FG/16/21/PL

Phoenix House Ferring Grange Gardens Ferring BN12 5HS

*Conversion of garage into bedroom & replace existing conservatory roof to solid roof with Velux
(resubmission following FG/144/20/PL)*

PROJECT Chambers ,No.23	DRAWING NO. 1459-P301	SCALE 1:100 @ A3	27 Oct	A 2020	
ADDRESS No.23 Heathfield Close Worthing	DRAWING TITLE Proposed Elevations	DRAWN BY CRE8TIVE LINES - ROZ NOWAK			
RICT COUNCIL FG/16/21/PL BN13 1LJ

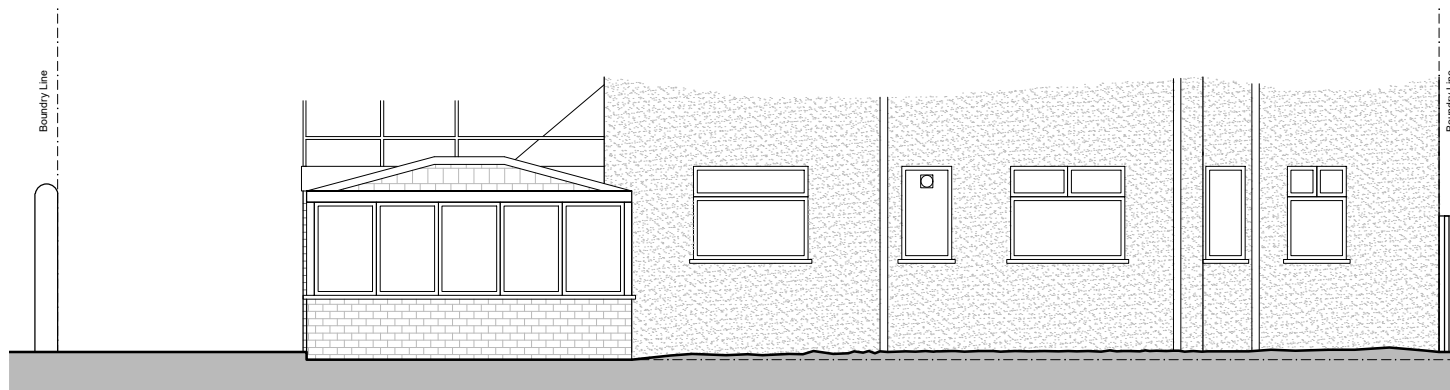
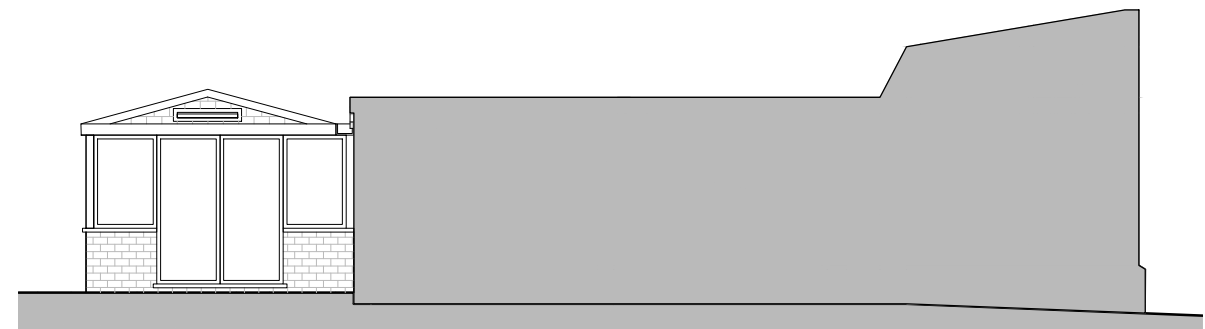
The replacement of the modern garage door and rendered section of walling will not harm either the building, character of the local area or neighbouring listed building. This is subject to details of the new window, brick and brick bond, details of which can be provided for by way of condition should you be minded to approve the application.

The proposed alteration to the conservatory will be on the rear elevation of the building. It would appear that this elevation has already been impacted as a result of the fire and conversion to apartments and is of less significance. The alteration would not be visible from the various heritage assets and is also considered to be acceptable.

- Details of the proposed window
- Details of materials e.g., brick
- Details of the brick bond to be used in the section of walling to replace the garage door
